Letter No. **A1/39720/2003**

Dated: **15.3.04**

Sub: CMDA ÷ **Planning permission - construction of Ground floor + first floor residential building at Plot No. 16/B/2, Officers Colony, Ayanavaram Chennai - 23 in T.S.No. 1/19(part) Block No.23 of Ayanavaram - Development Charges and other charges to be remitted - regarding**

TERRACE FLOOR PLAN

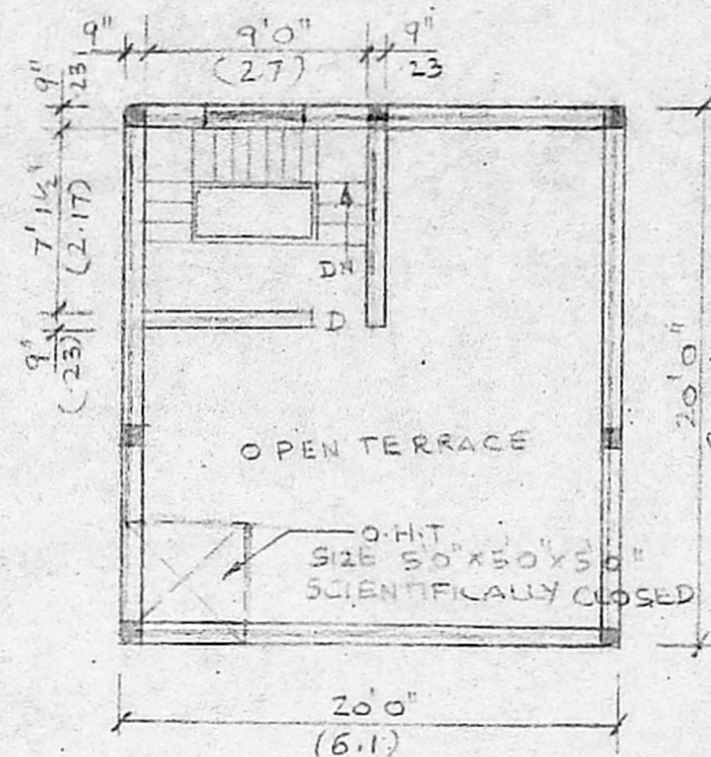
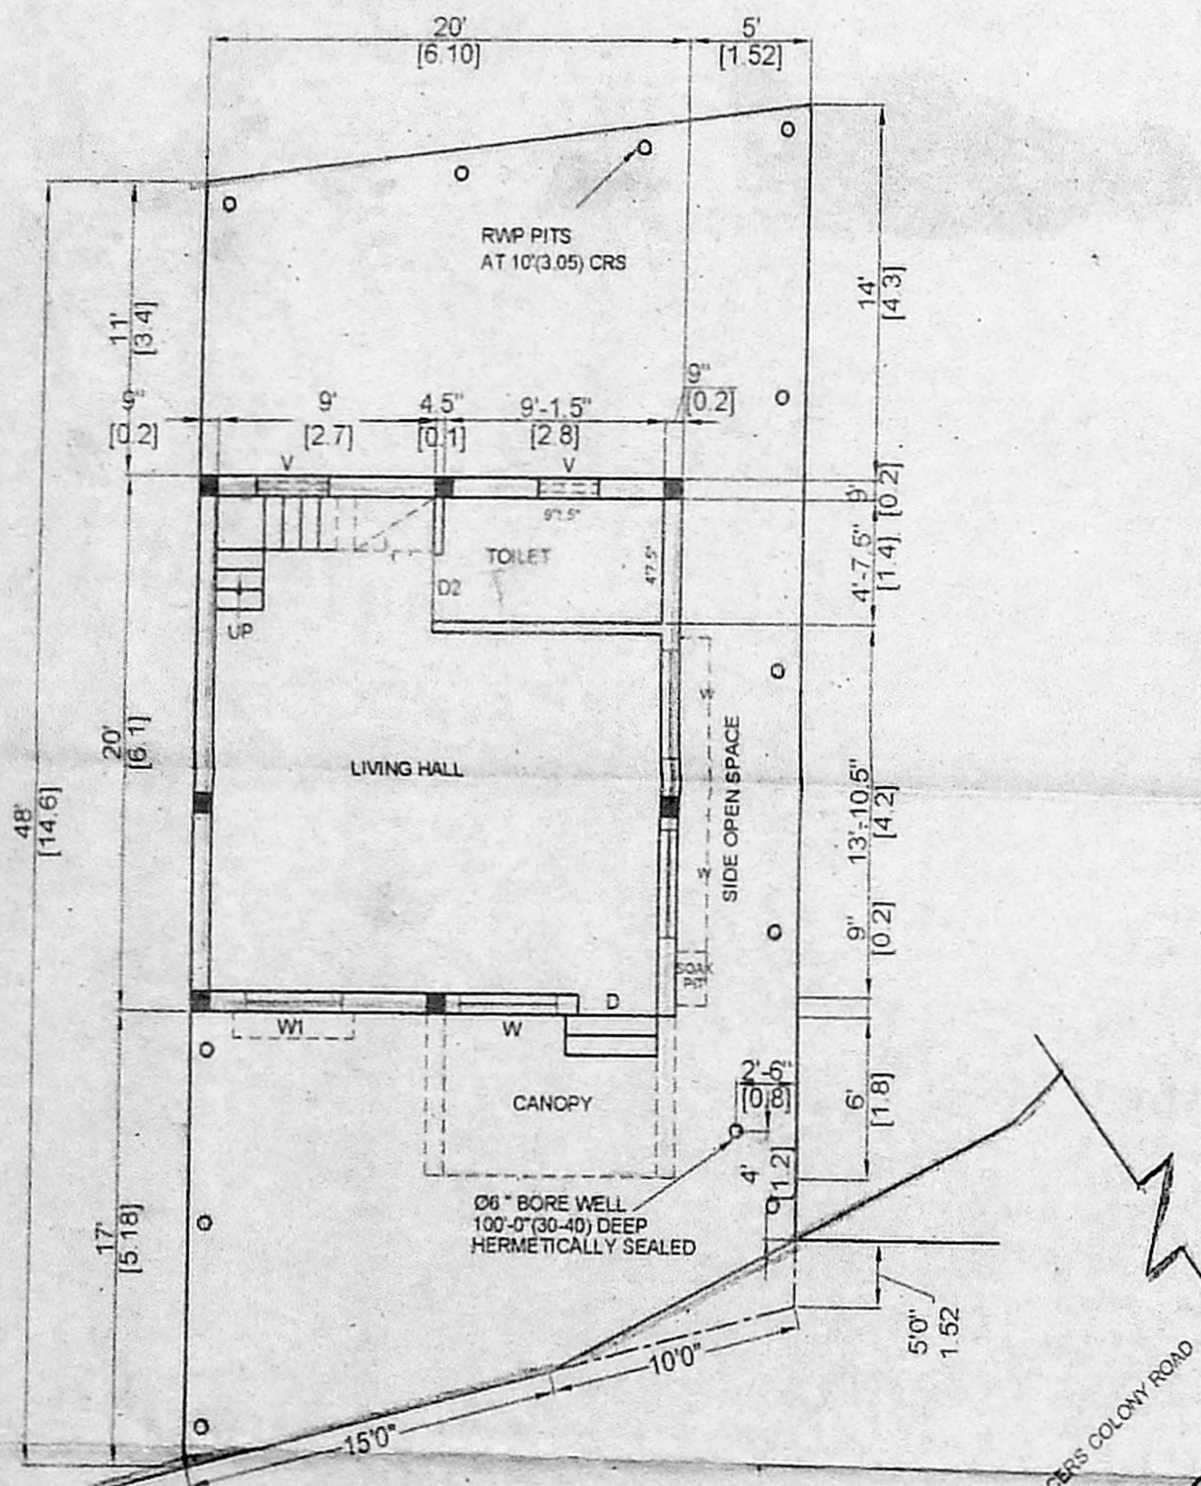
- a) Rain water conservation regulations stipulated by CMDA should be adhered to strictly.
- b) 5 copies of revised plan showing the terrace floor plan**
- c) The T.S.No. 1/19 part has to be indicated in the title of the plan**
- d) Copy of earlier approved plan for Plot No. 16A attested by Corporation officials to be furnished.**
